Subject: R/31/22/HH. 15 Broadmark Way, Rustington

I refer to the above Planning Application on which we would wish to make the following comments:

Elevations (1:100)

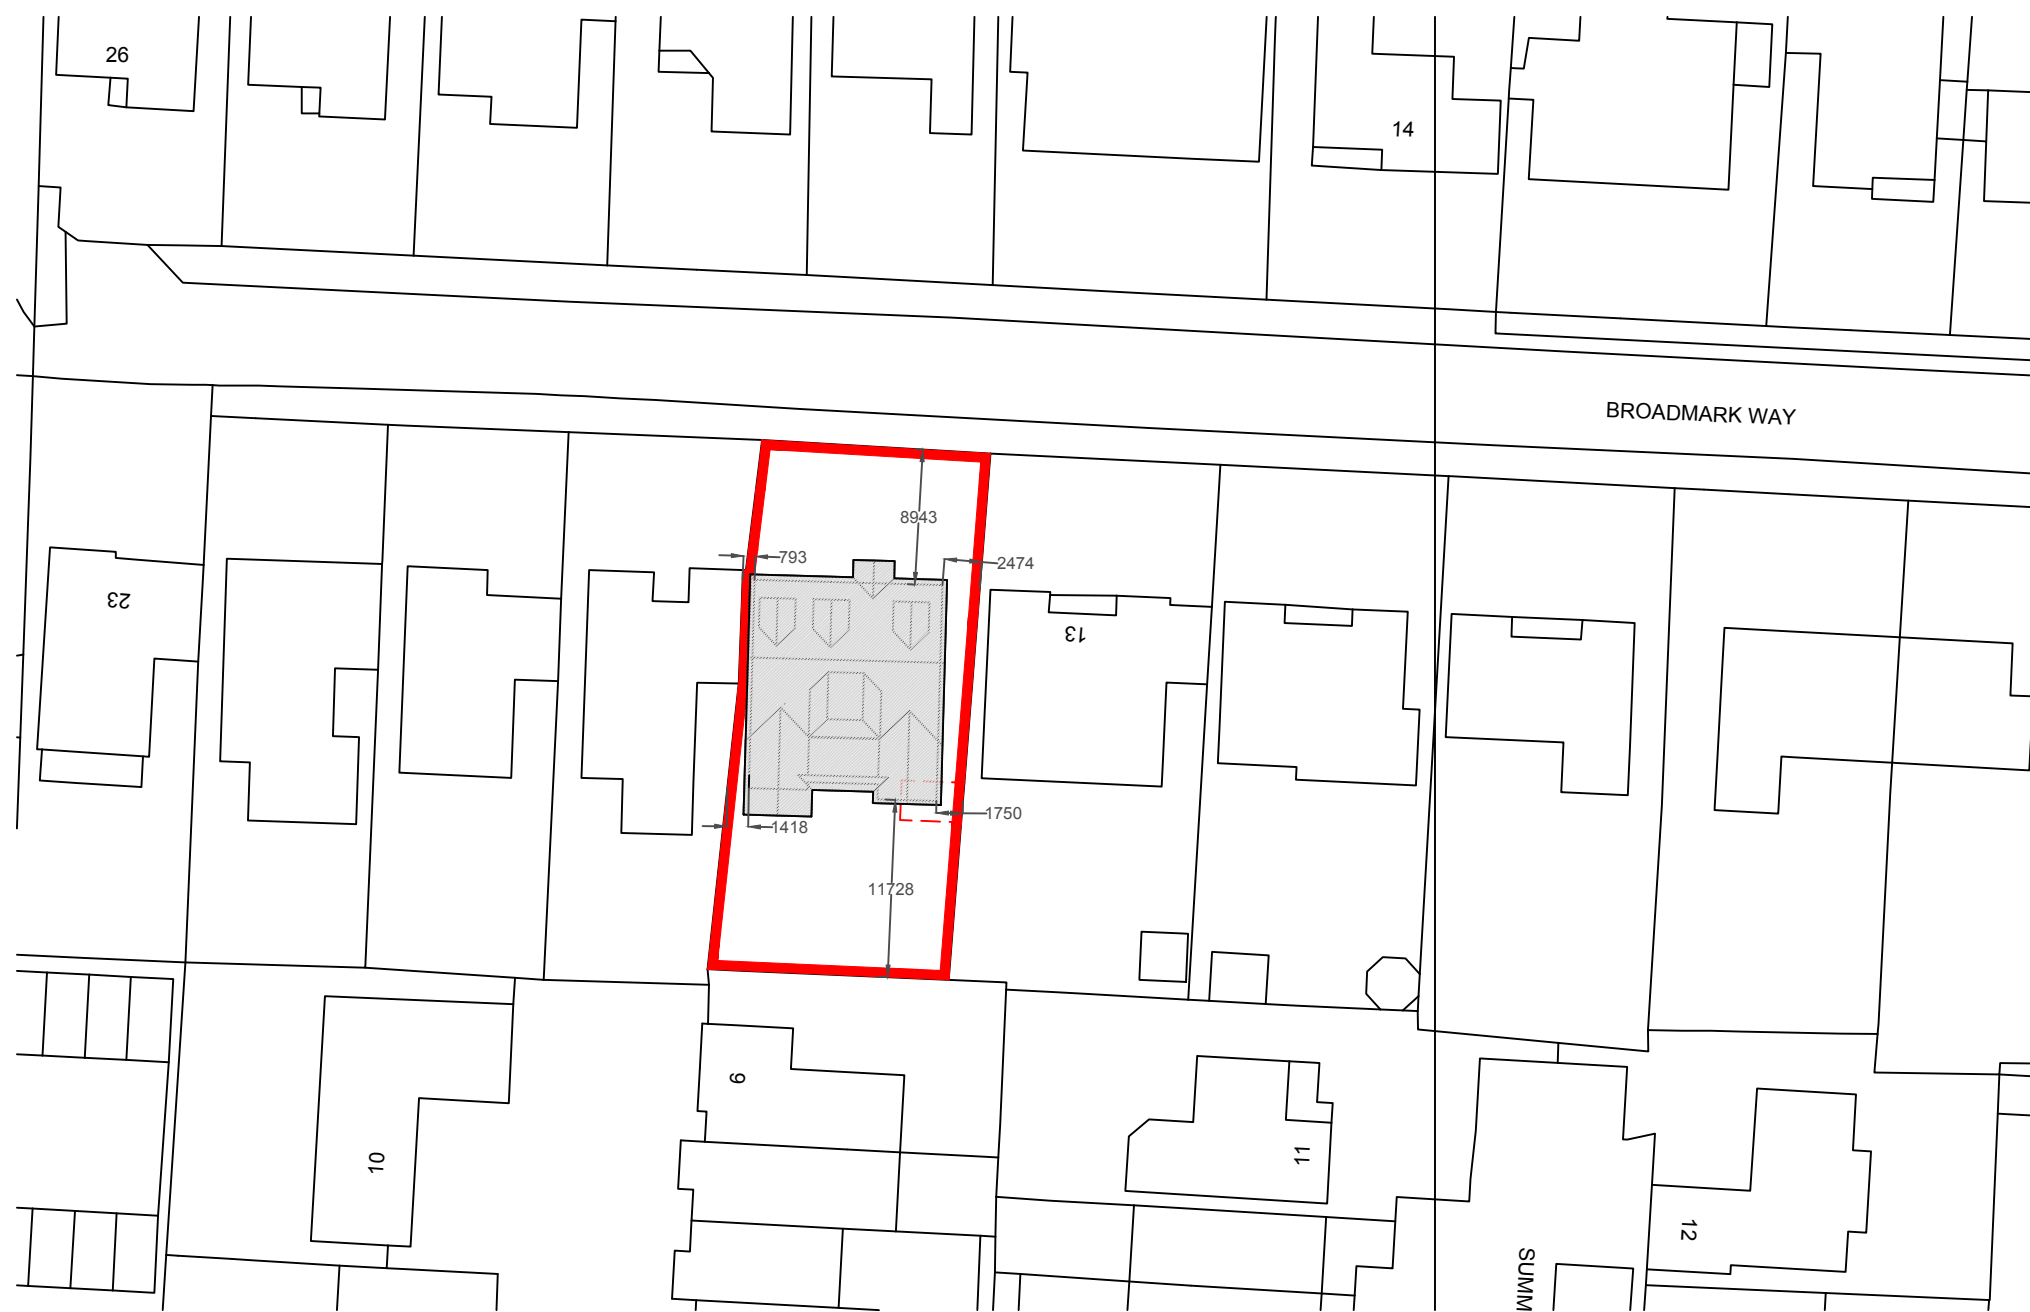
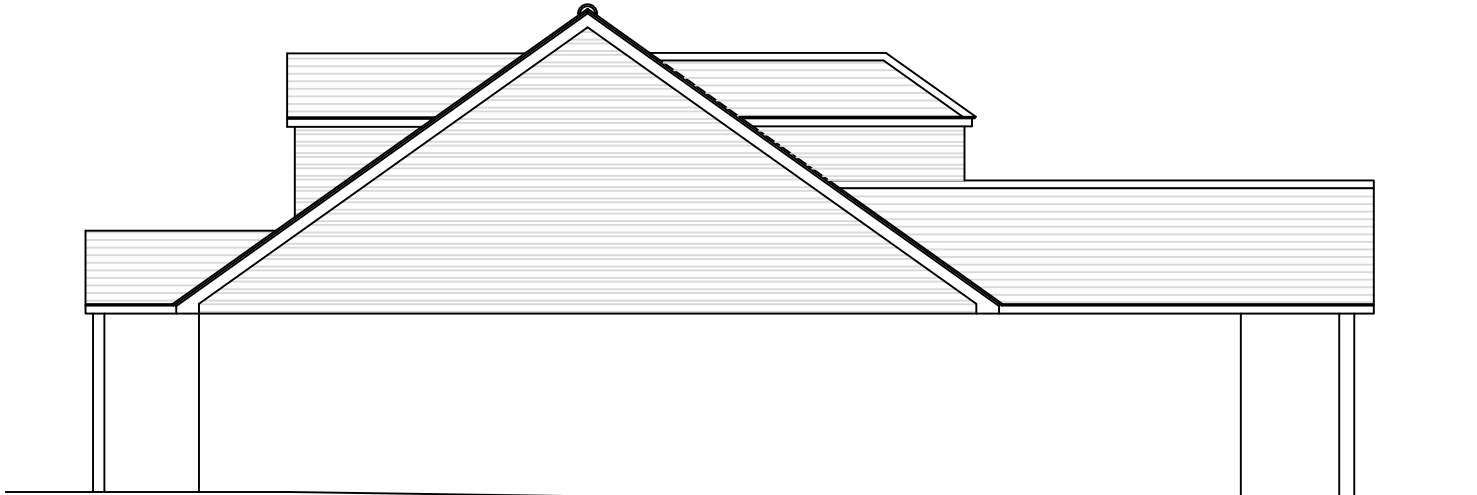
We are the owners of the bungalow at 13 Broadmark Way and feel that to develop the neighbouring bungalow into a massive 5 bedroom chalet could intrude into our air space and privacy if the roof was reconstructed to a height higher than currently exists. Since moving here 8 years ago, number 11 Broadmark Way has now been redeveloped into a house from a bungalow. Effectively we will now be surrounded on all four sides by a chalet bungalow and houses, whereas previously bungalows existed either side of us.

In principle, we are not averse to an extension next door provided this does not in any way exceed the current bungalow height.
